**Re: Garcias Kitchen, 1736 Central Ave SW**  
**Request for Certificate of Occupancy- Transportation Development**  
Engineer's Stamp dated 11-03-2015  
Administrative Amendment Dated 11-13-2015 (J13-D096)  
Certification dated 11-23-2015

RE: **Garcia's Kitchen, 1736 Central Ave NW (J13D096)**  
**Request Permanent C.O. – Accepted**

RE: Garcia's Kitchen Food Production & Warehouse Final Certificate of Occupancy

RE: Re-submittal of Grading and Drainage Plan for Garcia's Kitchen Food Prep & Catering J13/D096

GRADING AND DRAINAGE PLAN

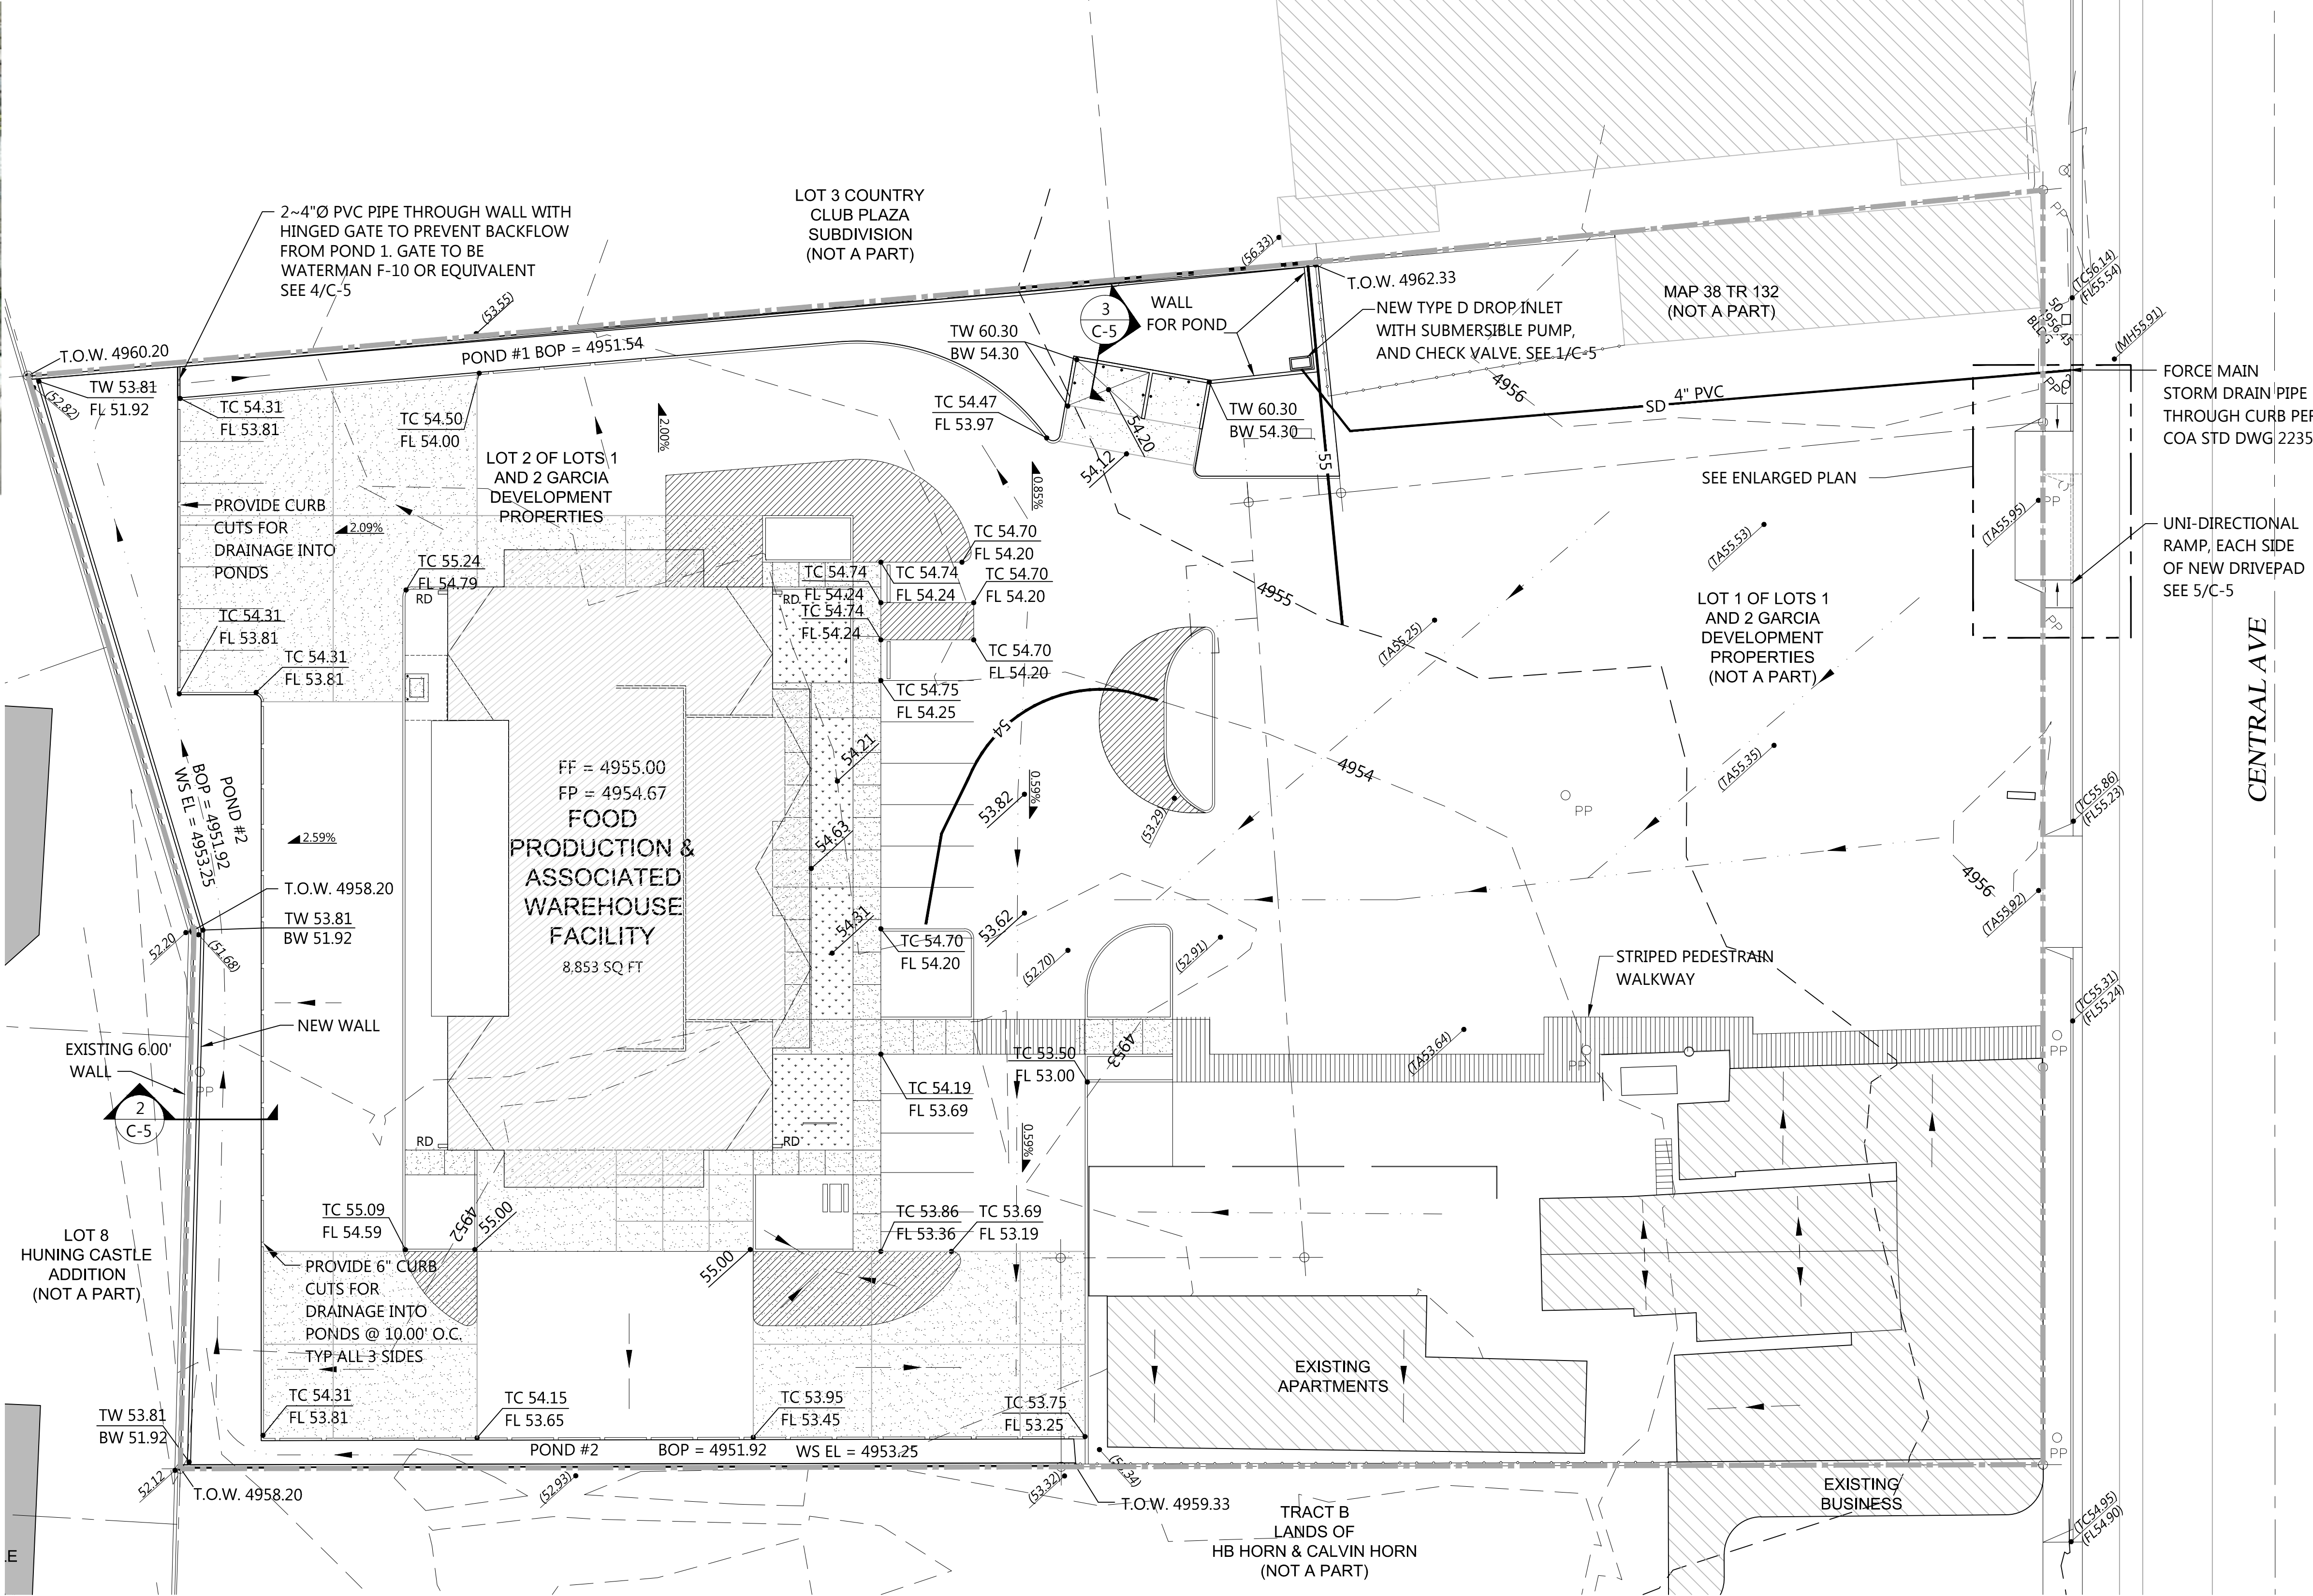
2. Onsite flows from the existing restaurant and apartments must be accounted for. The proposed curb south of these existing structures does not allow roof runoff from these structures to drain to pond 2. The flows have been accounted for in the calculations; a swale has been added east of the apartments to assure the runoff goes into pond 2. In addition a curb cut has been added to allow for drainage to enter pond 2.

3. Roof runoff from the apartments appears to drain offsite to east and then reenter the property and drain to the south west, along with some amount of offsite flows. LIDAR contours support this and so this onsite/offsite flows need to be accounted for. In addition, it appears that a wall is to be built along west property boundary. How will flows from apartments reenter? Some of the runoff from the apartments goes offsite historically. This plan does not plan to modify this condition except to collect the runoff from the east side of the apartments into a swale and direct to the pond. Off site grading is not proposed.

5. It appears that Pond #2 volume should be the total volume of both ponds #2 and #3 from the previous submittal. With a combined larger volume the WSEL will be lower. ~~Not correct.~~ The WSEL Elevation calculated for the previous submittal took into consideration the total volume of Ponds 2 and 3. The previous submittal missed the volume of pond #2 when the two were combined that has been corrected.

1
C-5

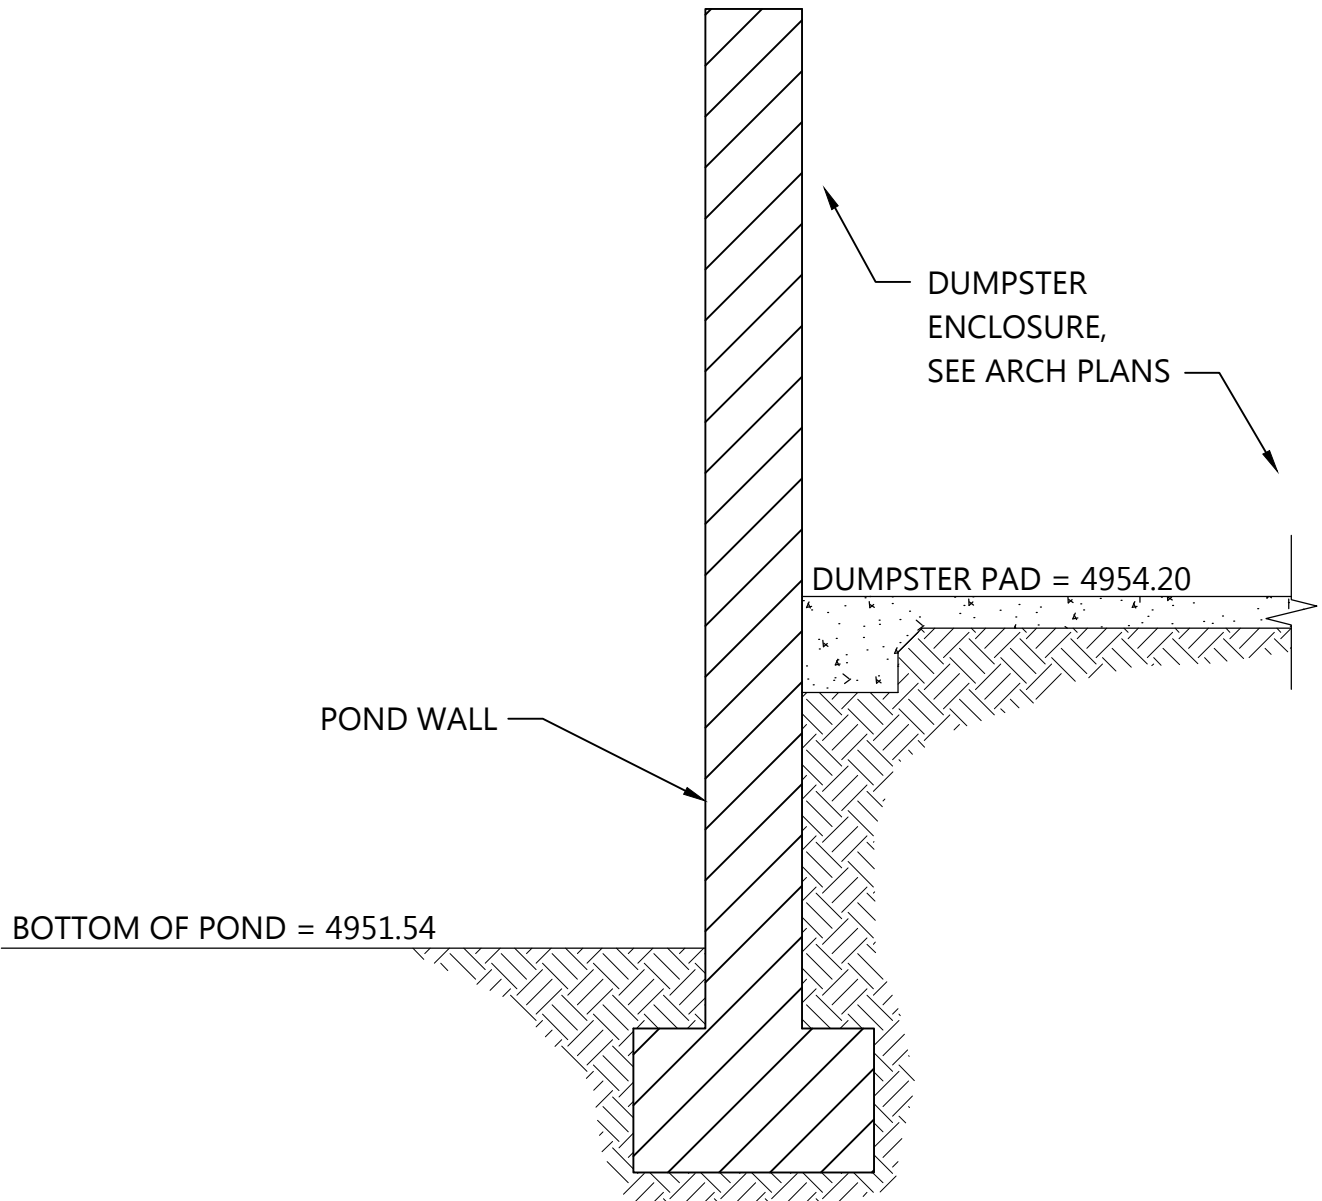
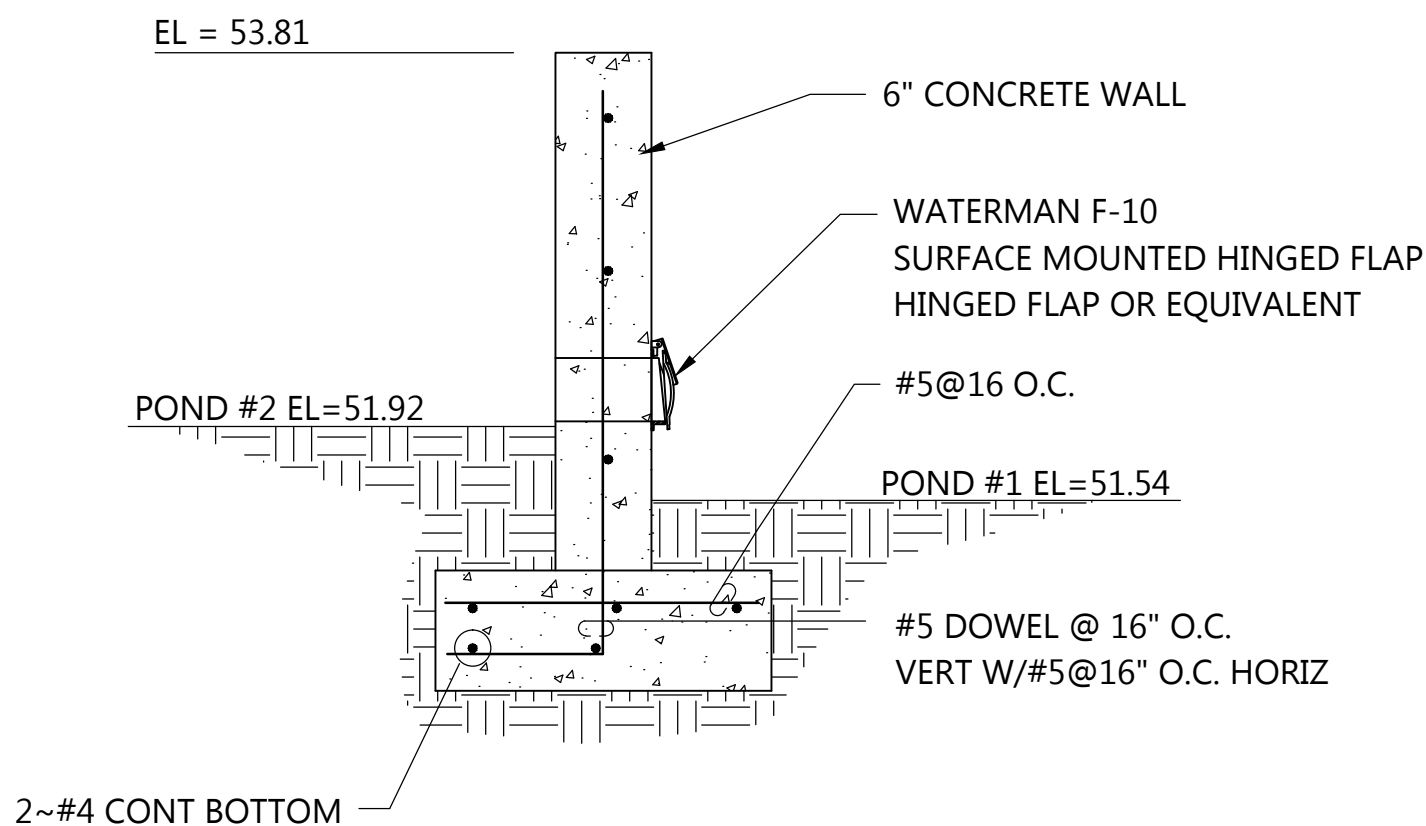
7. Details 1/C5 and 3/C5 show retaining walls that need to be designed, detailed, and dimensioned. ~~The retaining wall designs and details are included as part of the building permit submittal for the Garcias Food Preparation Facility Construction Plans.~~
